Please ask for: Mrs D Johnson
Email: daun.johnson@arun.gov.uk
Telephone: 01903 737762
Our Ref: P/155/21/RES
Your Ref:
Date: 12th November 2021

Application for Approval of Reserved Matters Following Outline Approval

Development: Approval of reserved matters (layout, scale, appearance and landscaping) following outline consent P/140/16/OUT for the 'local centre' parcel which comprises of retail, community and commercial uses, 20 No residential apartments and a 70 bed care home.

Location: Land West Of Pagham Road Pagham

SF Plan

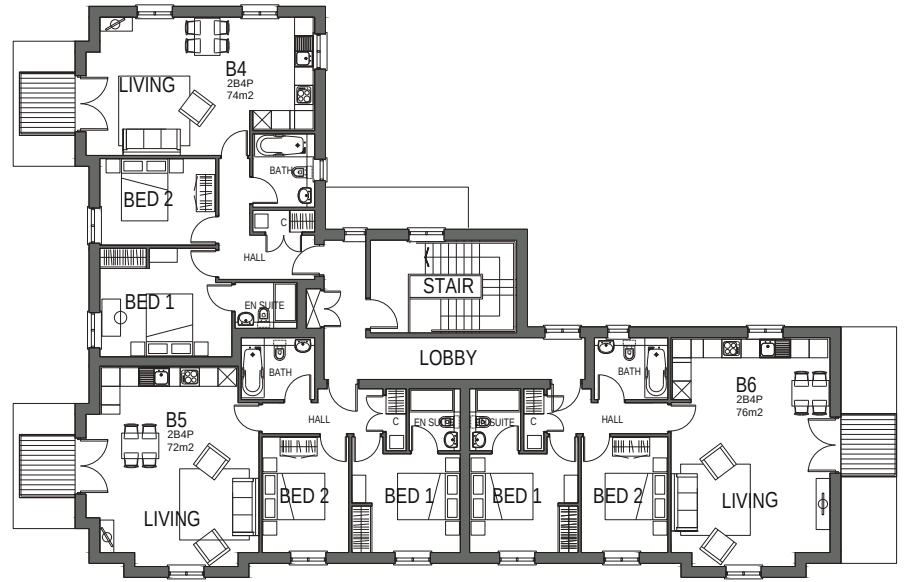
Block A second floor plan and south elevation do not accord. Please amend accordingly.

GF Plan

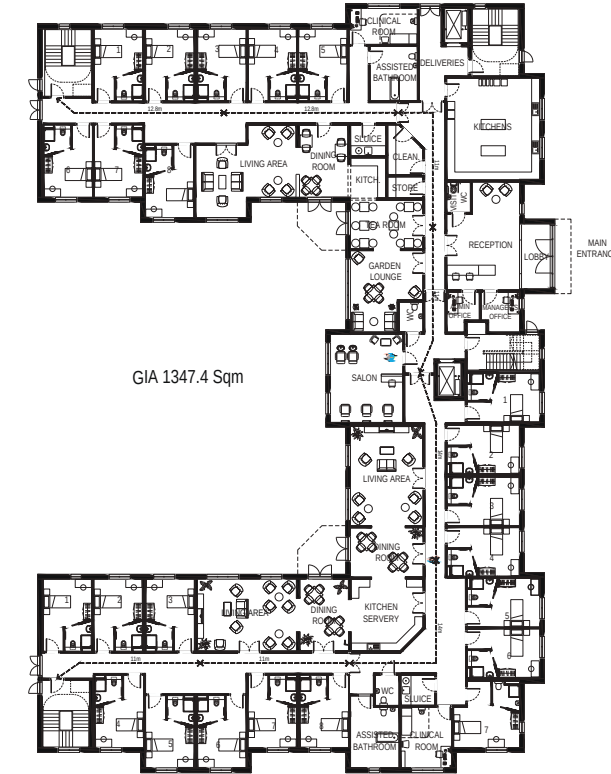
The Care Home ground floor plan and north and west elevations do not accord. Please amend accordingly.

SF Plan

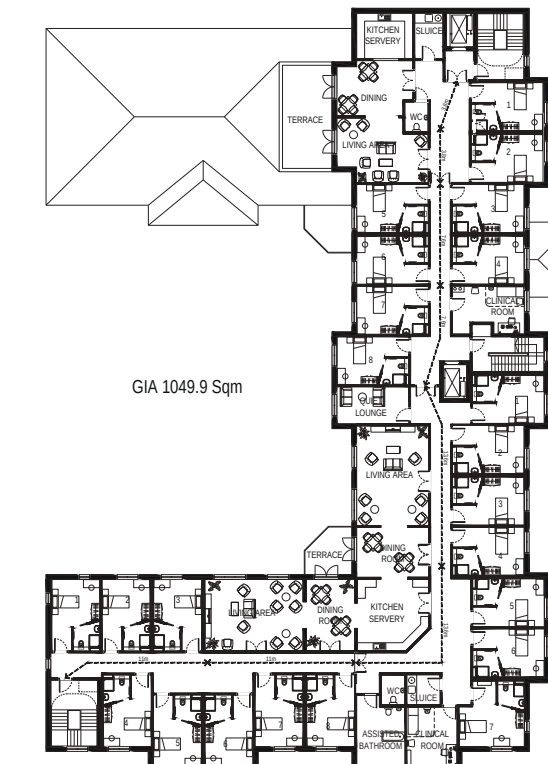
The Care Home second floor plan and north elevation do not accord. Please amend accordingly.
